Subject: 88 Ancton Way Elmer Middleton-On-Sea PO22 6JP - M/6/22/PL

Planning Application Reference: M/6/22/PL

Proposal: Demolition of existing bungalow and erection of 1 No 2-storey, 4-bedroom detached house with 3 No off road car parking spaces. This site is in CIL Zone 4 and is CIL Liable as new dwelling.

Drawing Title:
Proposed Plans

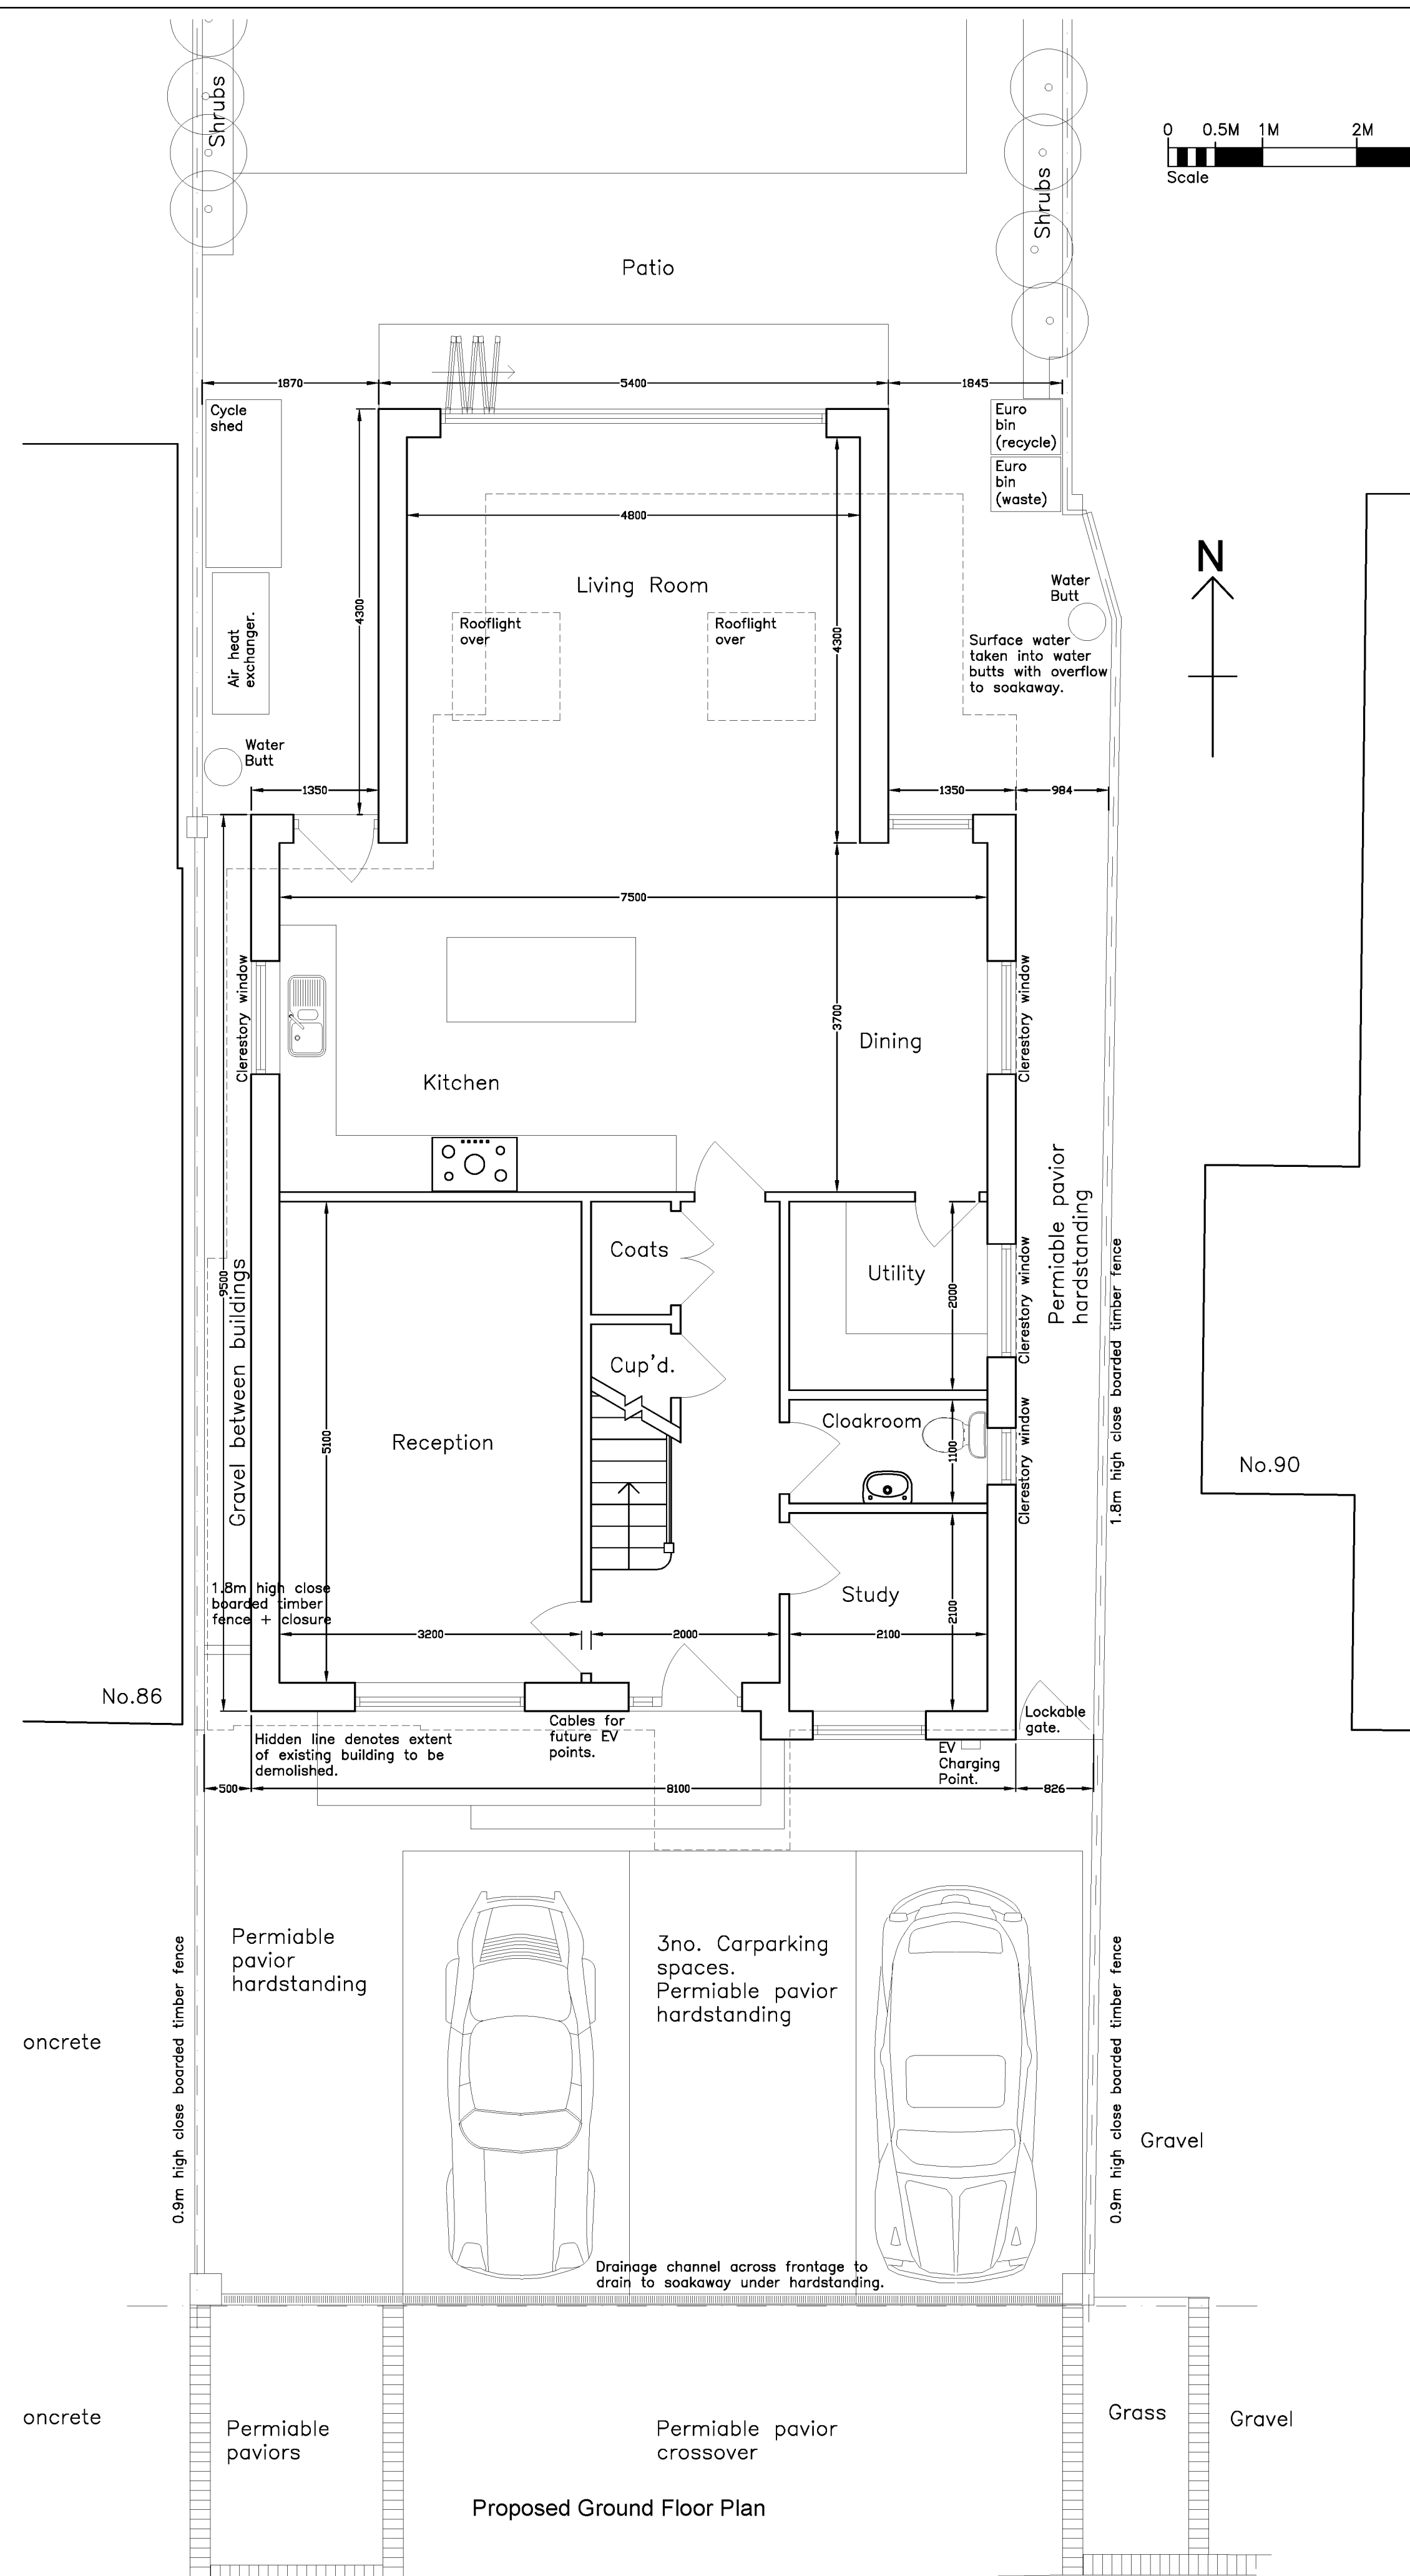
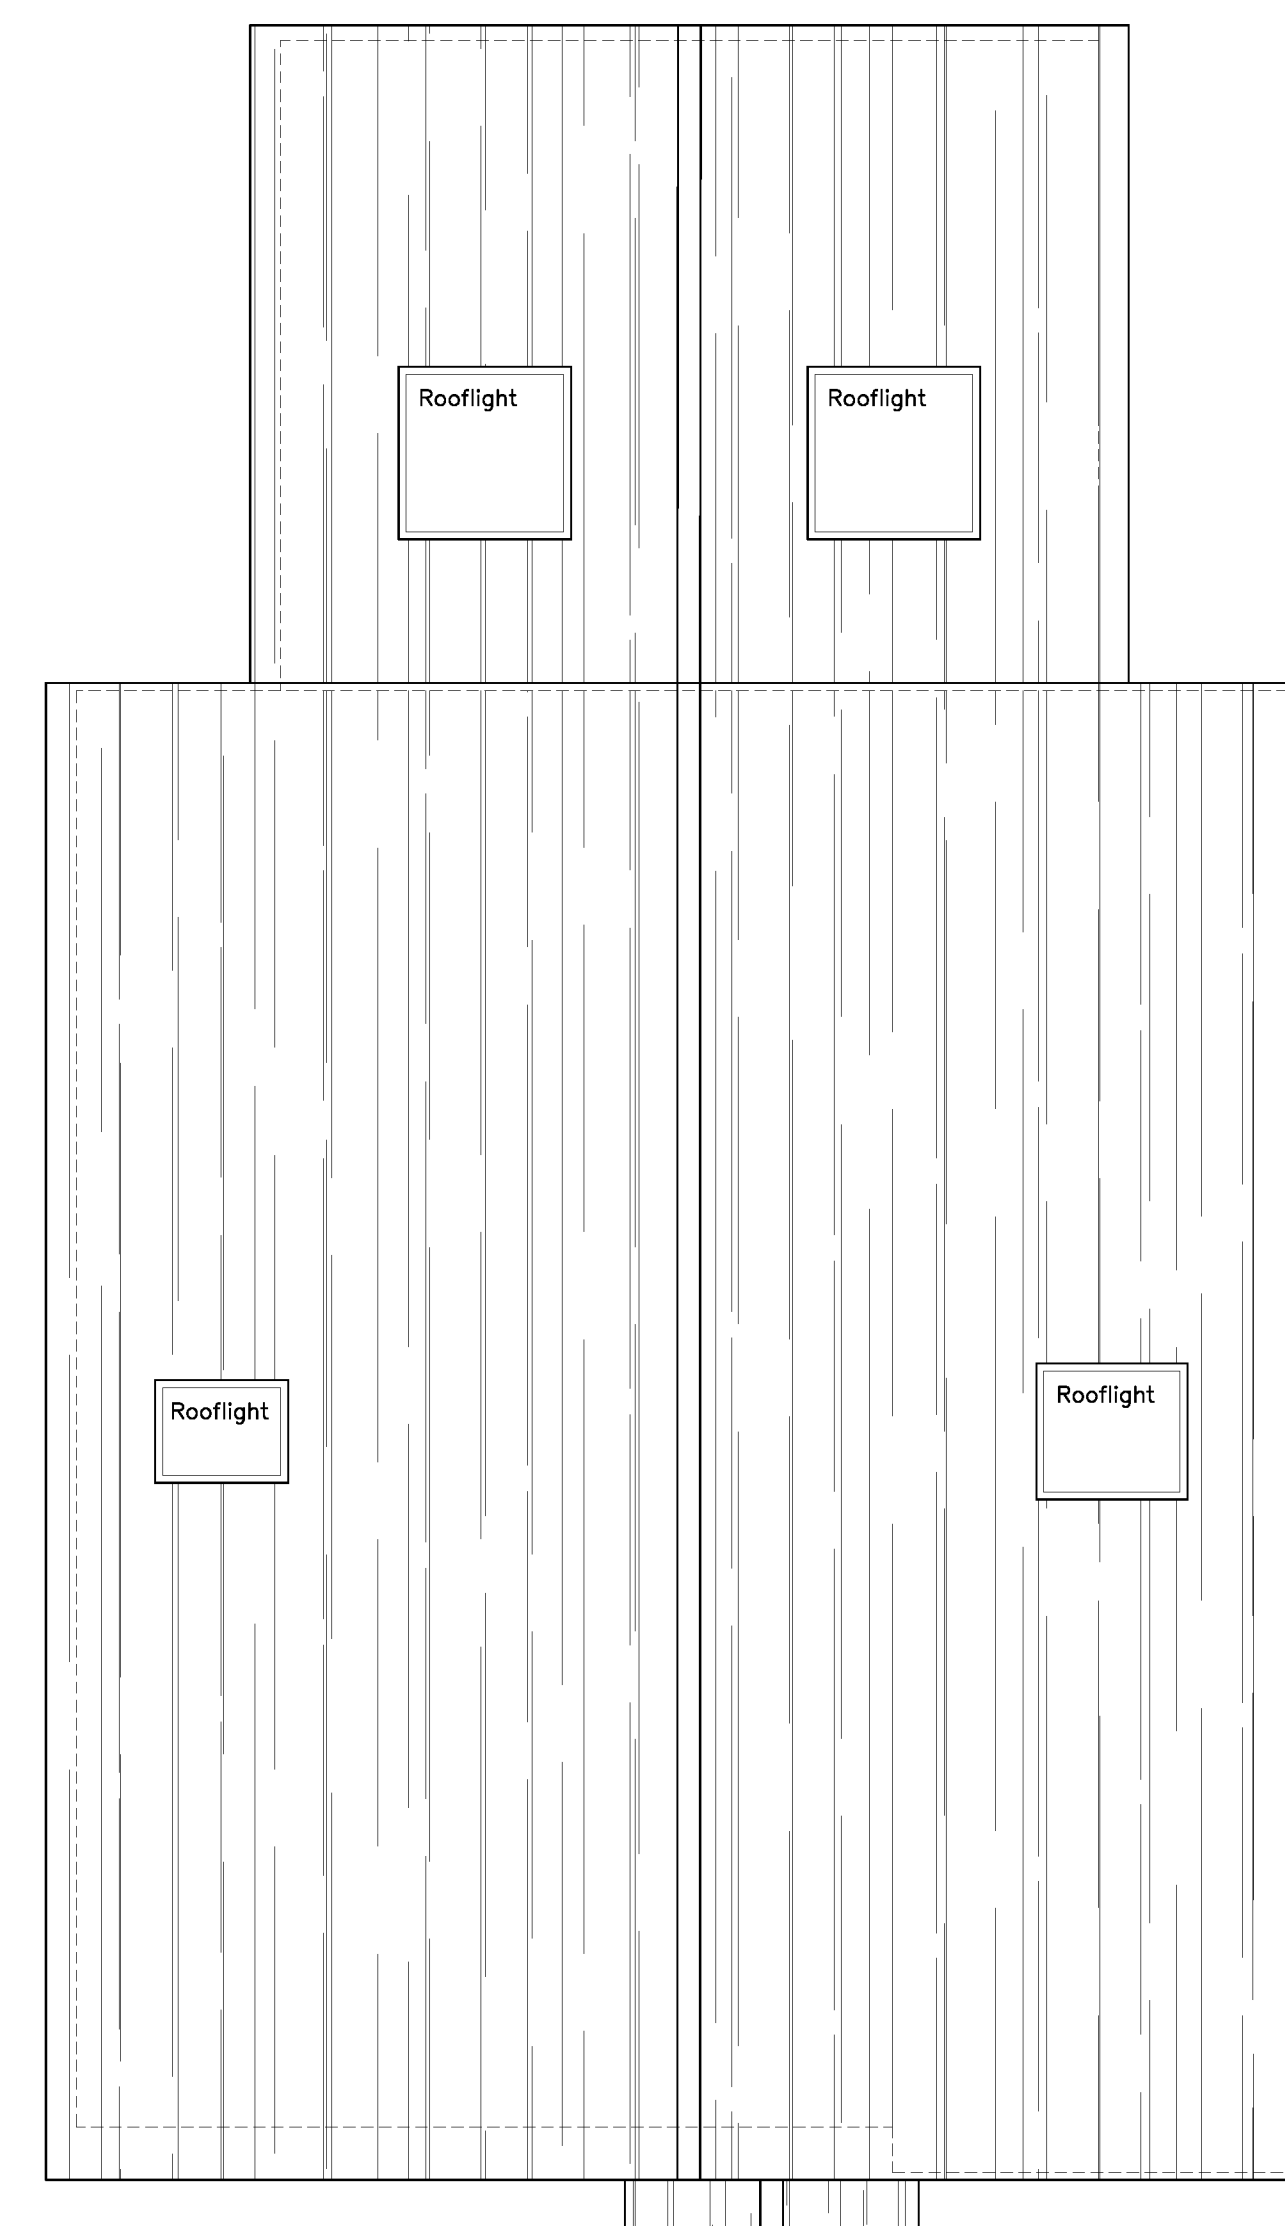
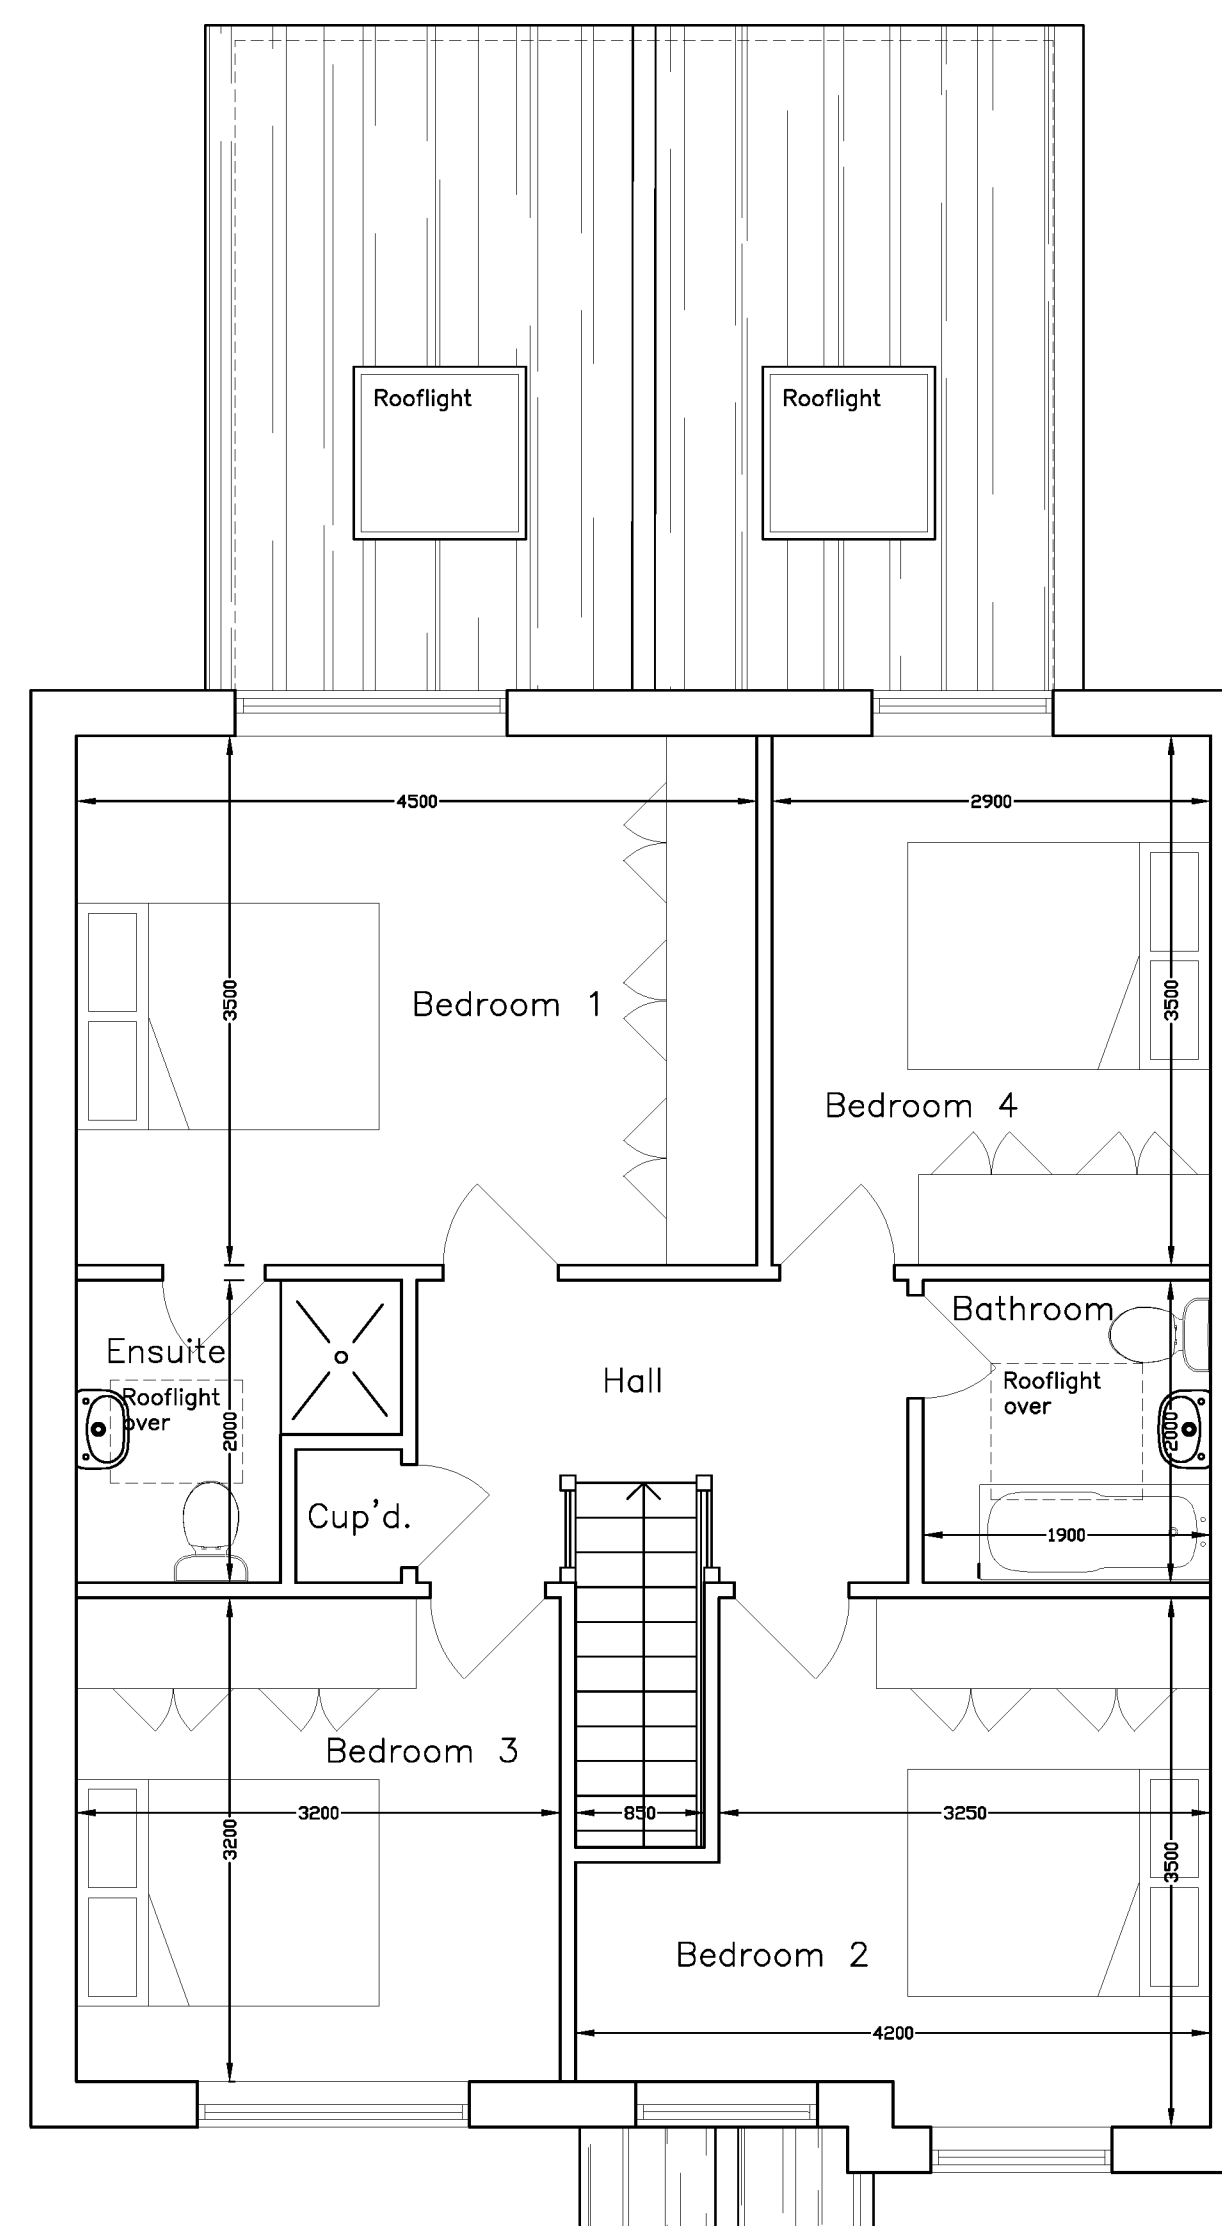
I note from the document entitled 'Proposed Plans | Dwg. No. 6778 -05' (dated December 2021) [produced by Design Matrix UK Ltd.], I note the application includes the provision of 1 No. electric vehicle charging point and cabling to facilitate a future charging point. In the event that drawings are amended, at least 1 No. electric vehicle charging point shall be included with any permission granted. The type and manufacturer of charging point must appear on the government's document 'Electric Vehicle Homecharge Scheme Approved charge point model list', or demonstrate the proposed model is equivalent to approved manufacturers and models.
